**Re: *Townhomes at Western (SF2410) – Final Plat Comment Response Letter
MVE Project No. 61203***

The submittal documents for the Townhomes at Western plat have been revised and corrected per the comments received by the various reviewing agencies. Most of the revisions are provided in the submittal documents without further discussion. However, some of the comment responses require further explanations which follow in the notes below.

DATE:	21 MARCH 2024
DRAWING NO.:	- TOWNHOME
SHEET:	1 of 3

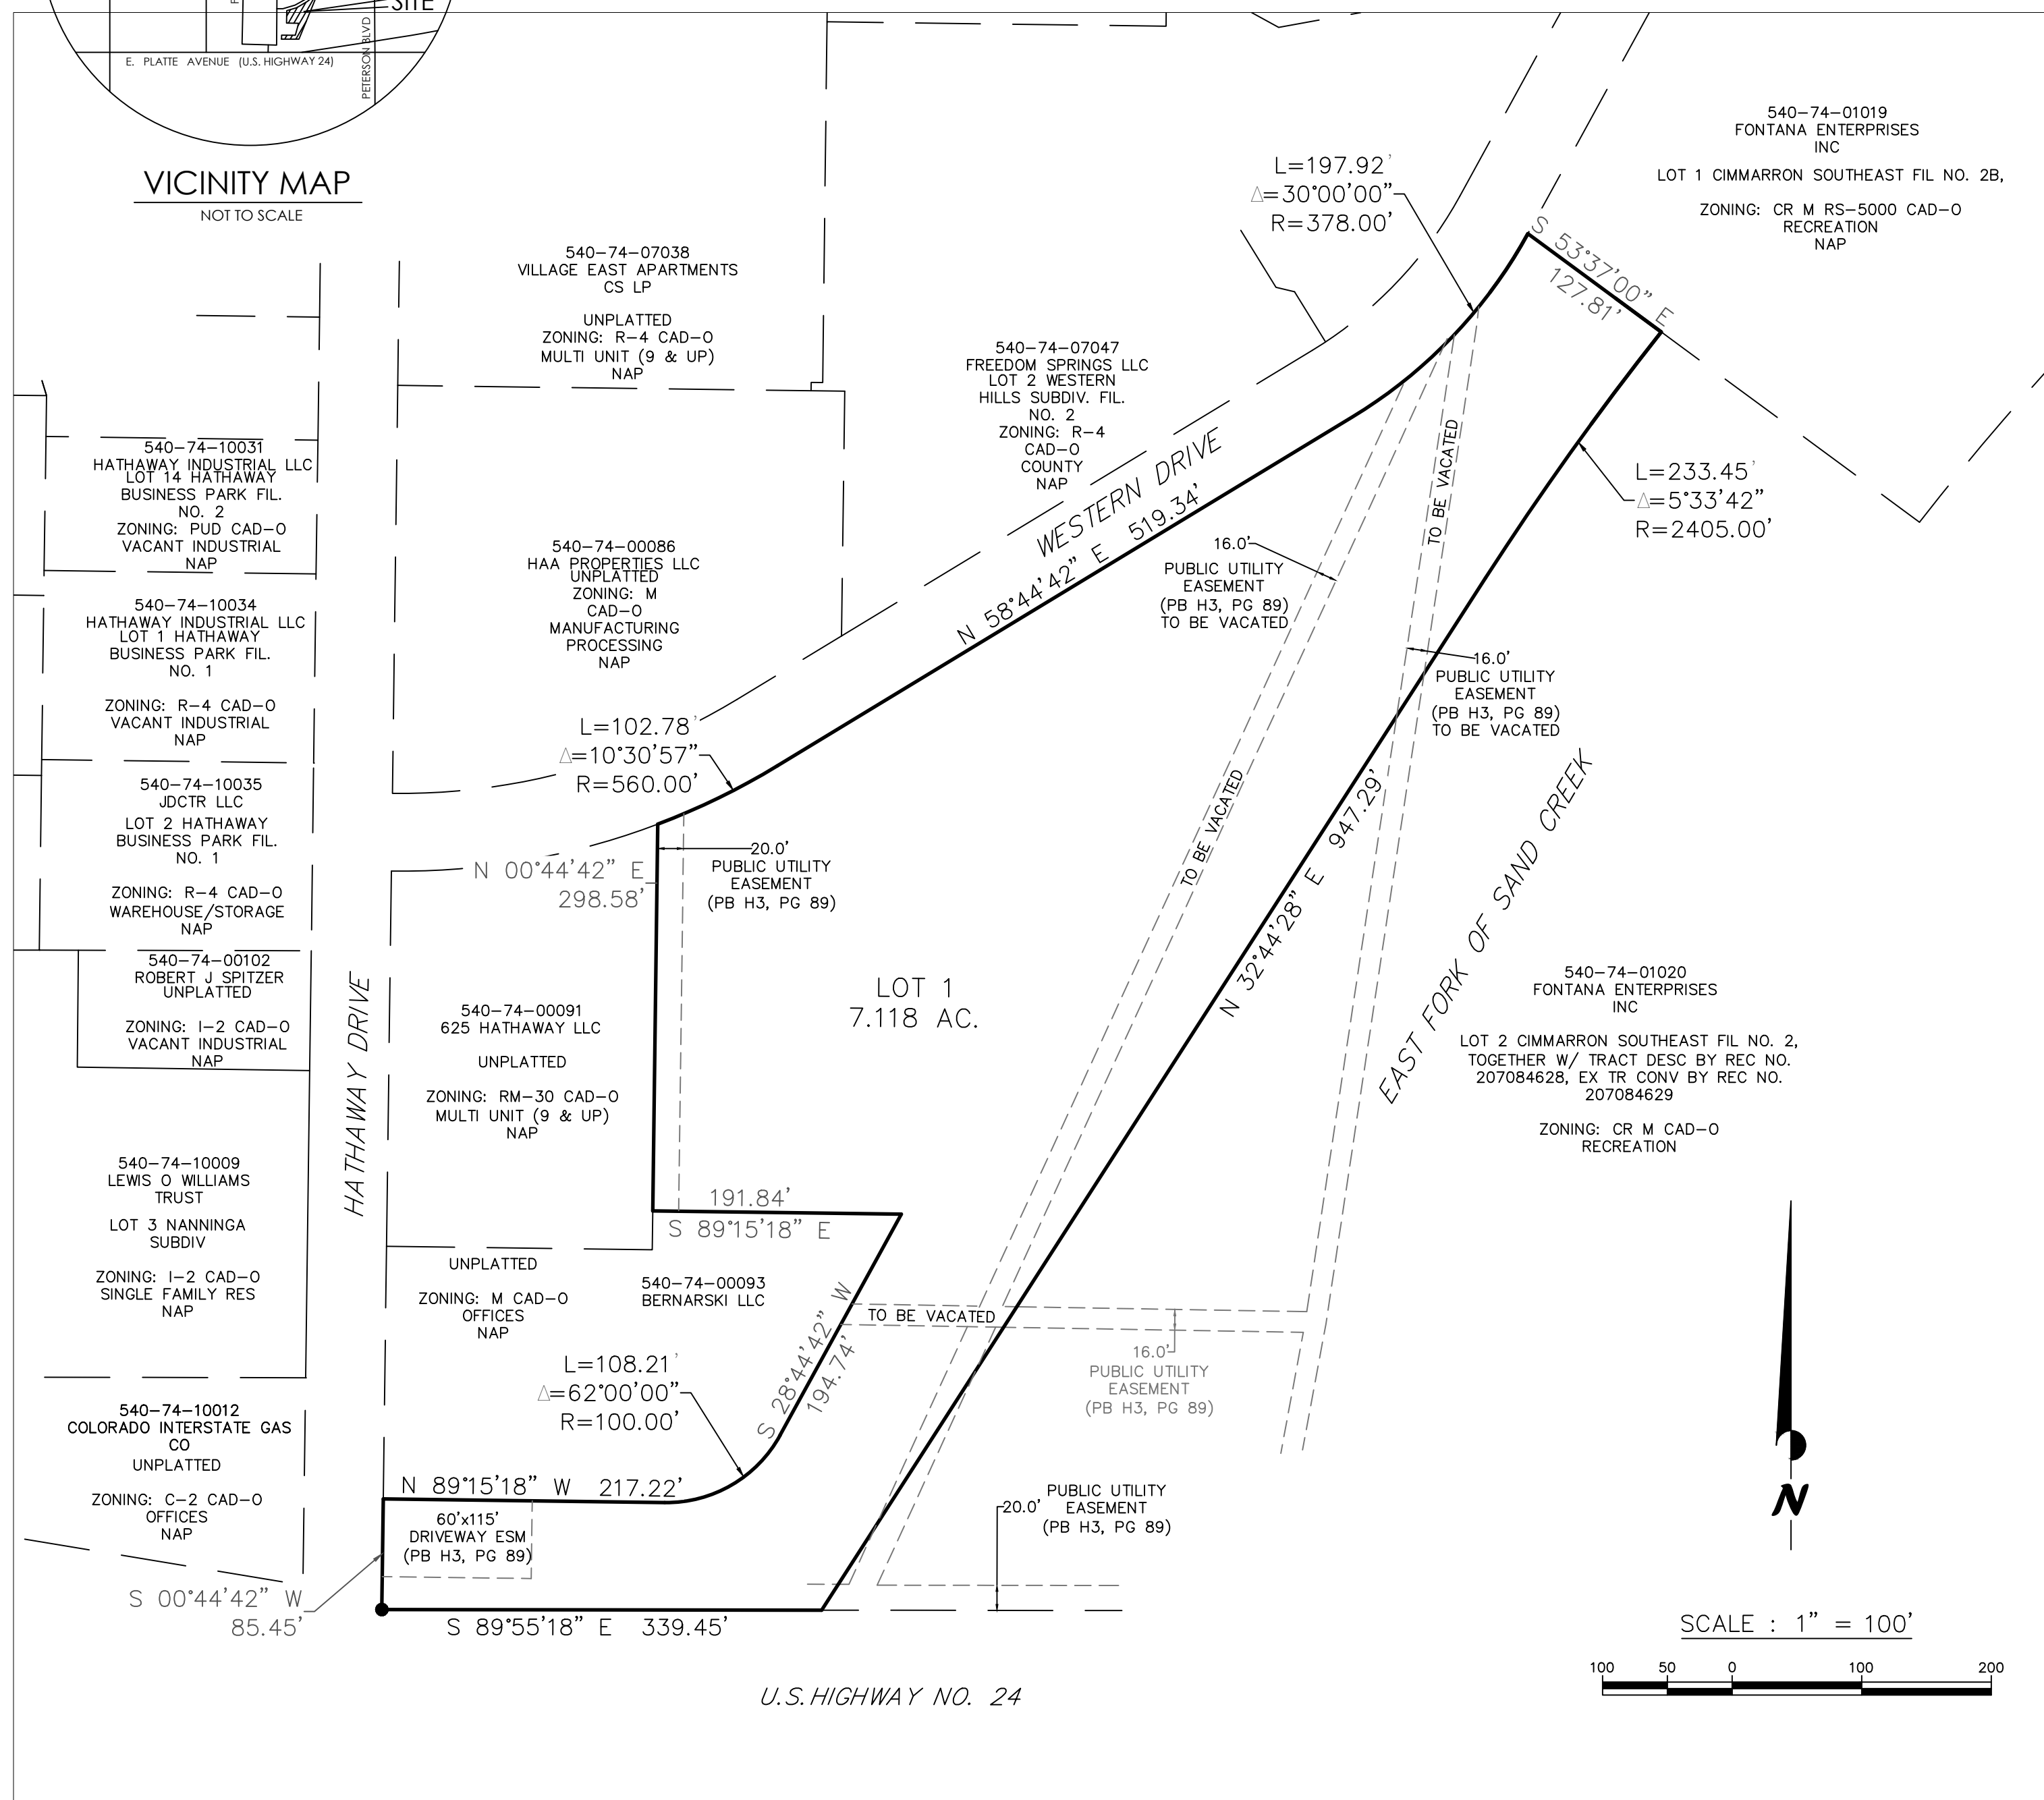
PCD Eng, Comment #2: “Please include the following note: Unless otherwise indicated, all side, front, and rear lot lines are hereby platted on either side with a 10 foot (use 5 feet for lots smaller than 2.5 acres) public utility and drainage easement unless otherwise indicated. All exterior subdivision boundaries are hereby platted with a 20 foot (use 7 feet for lots smaller than 2.5 acres) public utility and drainage easement. The sole responsibility for maintenance of these easements is hereby vested with the individual property owners.”

MVE Response: This is a Townhome Plat consisting of 52 UNITS (Not Lots) whose extents are the extents of each individual unit's footprint and a singular tract encompassing the remainder of the property. A note is added to provide that The exterior subdivision boundary be platted with a 20 foot public utility and drainage easement with the sole responsibility for maintenance of these easements being vested with the individual property owners. We discussed this in our 6/5/2024 meeting and agreed on the resolution.

PCD Eng, Comment #4: “Please show drainage easement for the detention pond, and outfall pipe.” and comment “Please include the following note: Lot ___ (or Tract ___) (or entire property) of this property is subject to a Private Detention Basin/Stormwater Quality BMP Maintenance Agreement and Easement as recorded at Reception No. _____ of the records of El Paso County. The _____ HOA (or Owner or District) is responsible for maintenance of the subject drainage facilities.”

MVE Response: The easement area indicated in the O&M Manual and Maintenance Agreement is Tract A. A note will be added to the plat stating that “Tract A of this property is subject to a Private Detention Basin/Stormwater Quality BMP Maintenance Agreement and Easement as recorded at Reception No. _____ of the records of El Paso County. The _____ HOA (or Owner or District) is responsible for maintenance of the subject drainage facilities.” We discussed this in our 6/5/2024 meeting and agreed on this resolution.

DRAWN BY:	TJW	DATE:	3/22/2024
CHECKED BY:	RDH	DRAWING NO.:	- TOWNHOME
JOB NO.:	230905	SHEET:	2 of 3

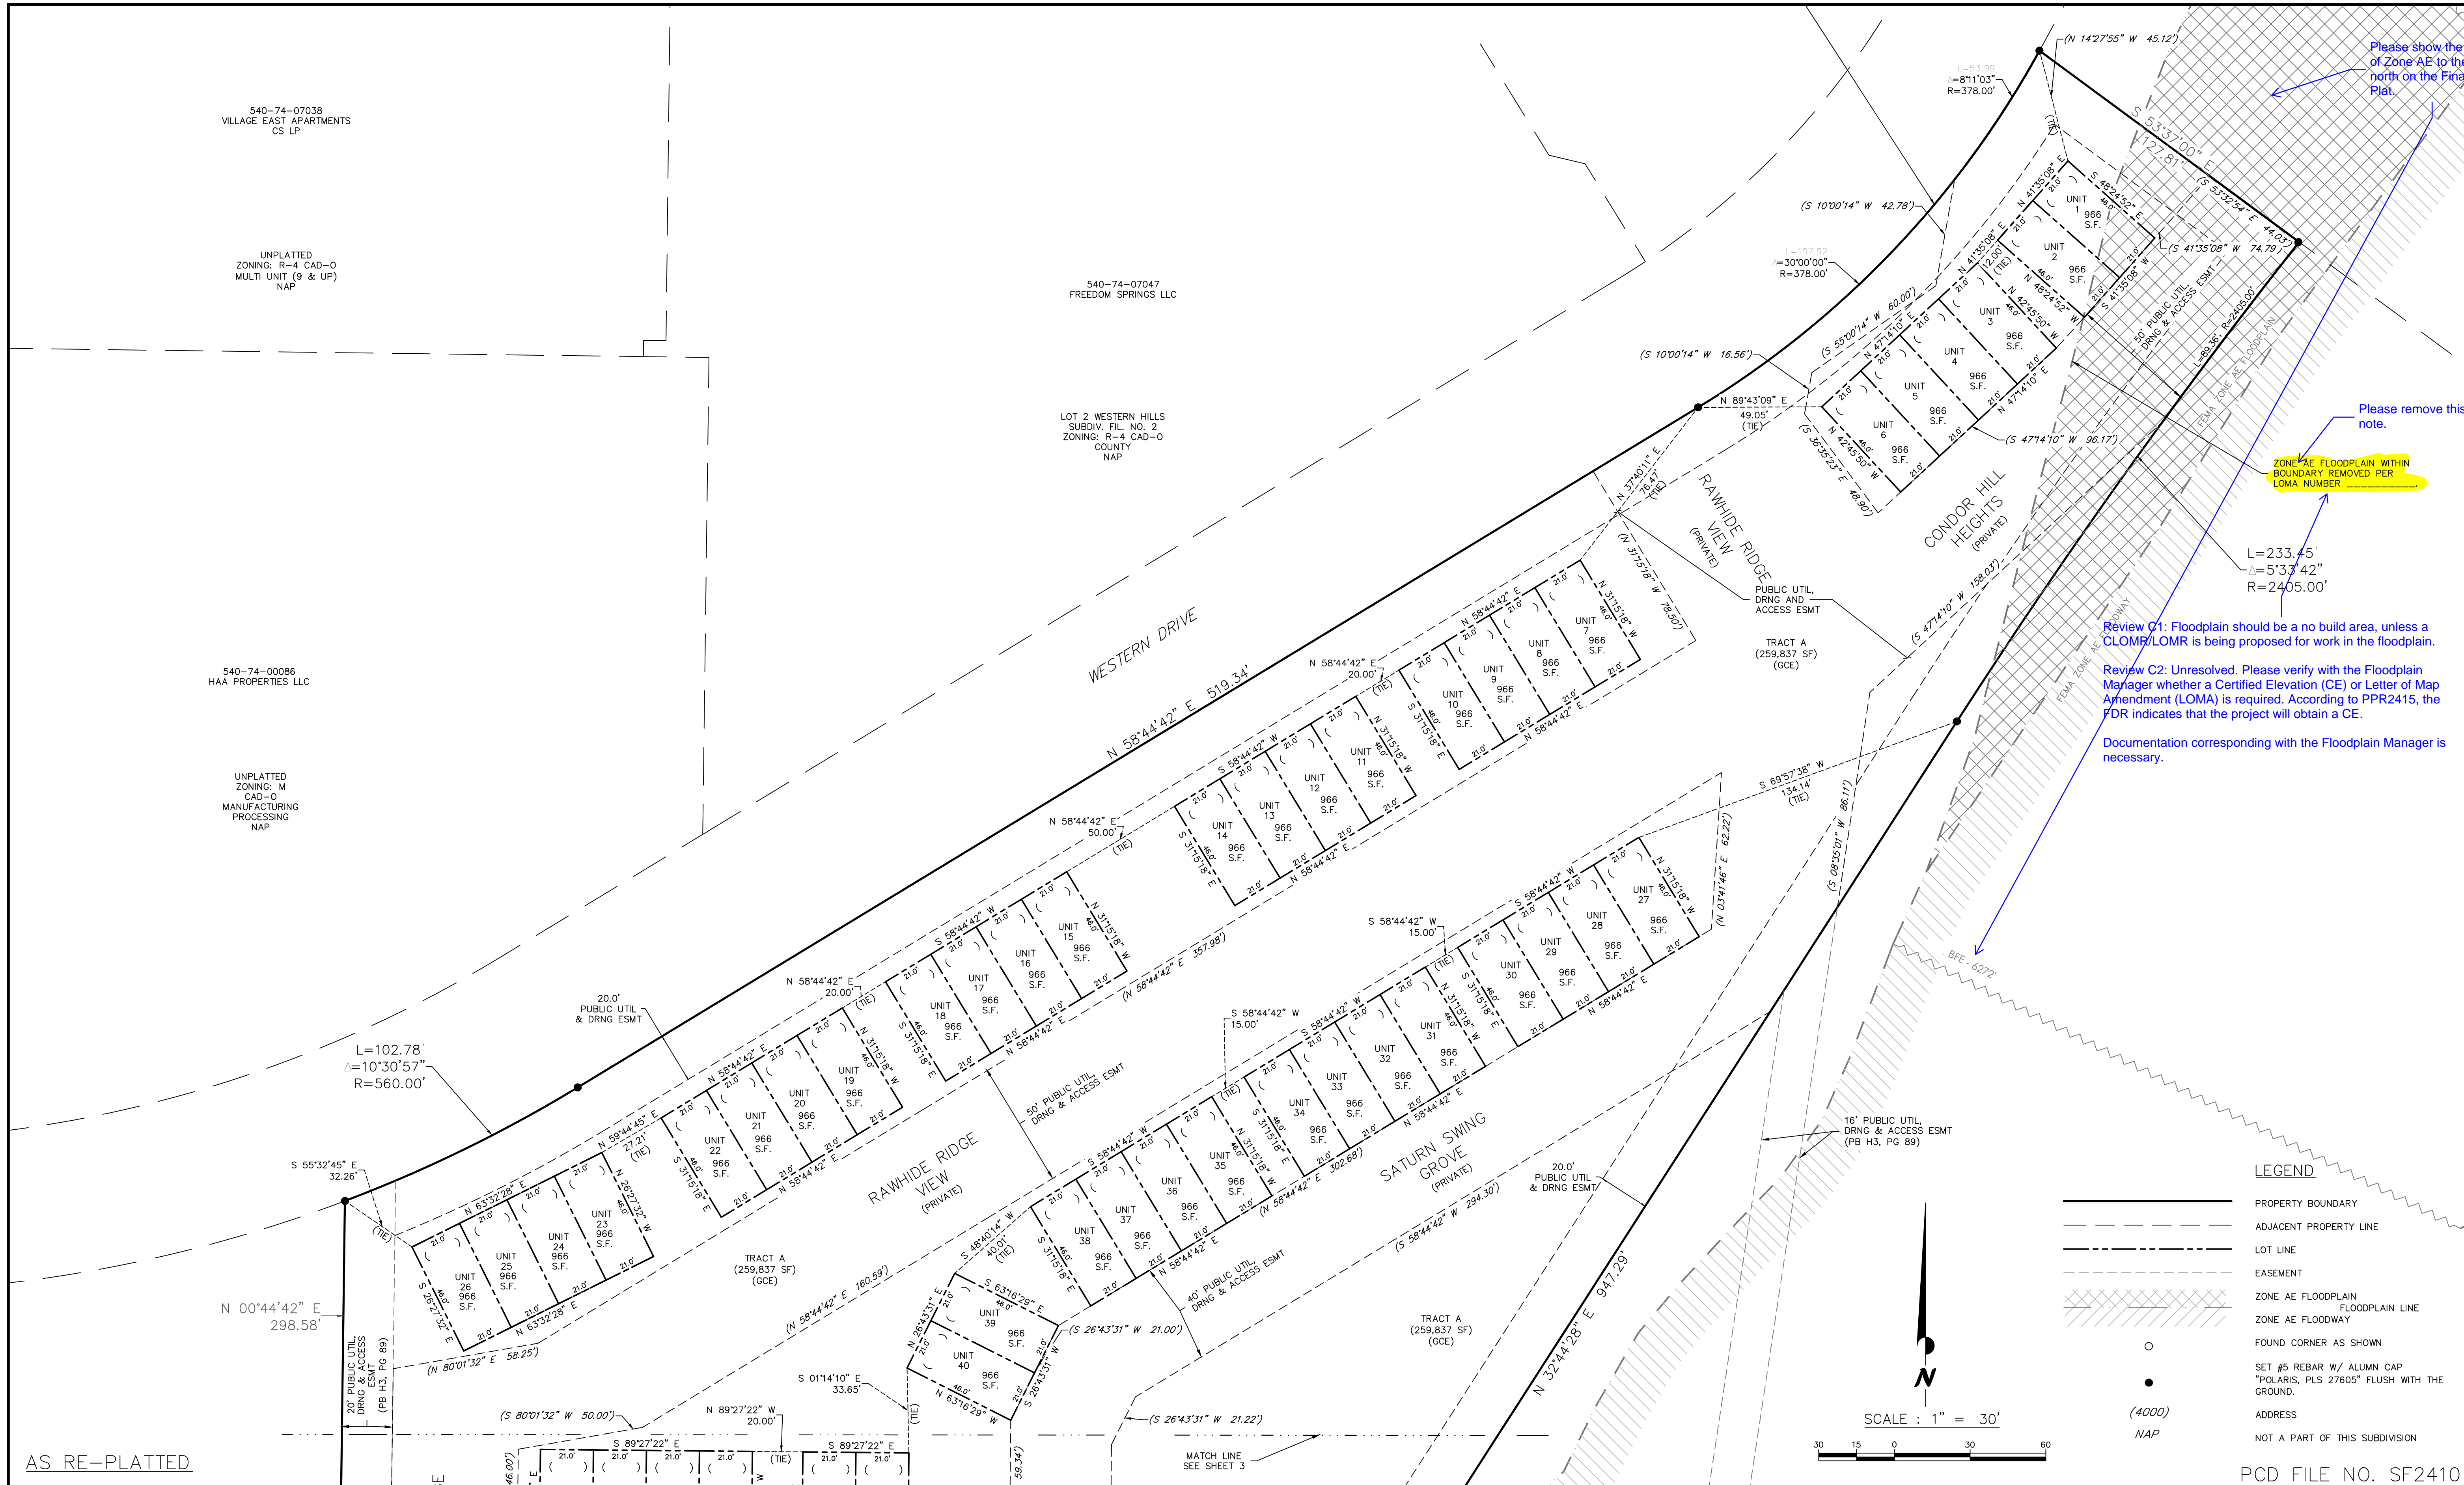
PCD Eng, Comment #1: “Floodplain should be a no build area, unless a CLOMR/LOMR is being proposed for work in the floodplain.” and “Please include the following note: No structures or fences are permitted within designated "Floodplain" or "Park and Open Space" areas. (Modification of this note may be allowed if the plan approved by the Floodplain Administrator, provided this creates no conflict with approved plans or conditions.)”

PPRBD Floodplain Comment: “Small portion of floodplain in the northeast corner needs to be contained in an easement or tract and designated no build no storage of materials. see attachment or Do a metes and bounds LOMA to show that the whole parcel is not in the floodplain.”

MVE Response: A metes and bounds LOMA application (Application ID: 5058933771690) has been filed with FEMA Online LOMC system to remove this area of the site from the floodplain as suggested. The application is in process. A note has been added to the plat with blank to fill in the approved LOMA number once complete.
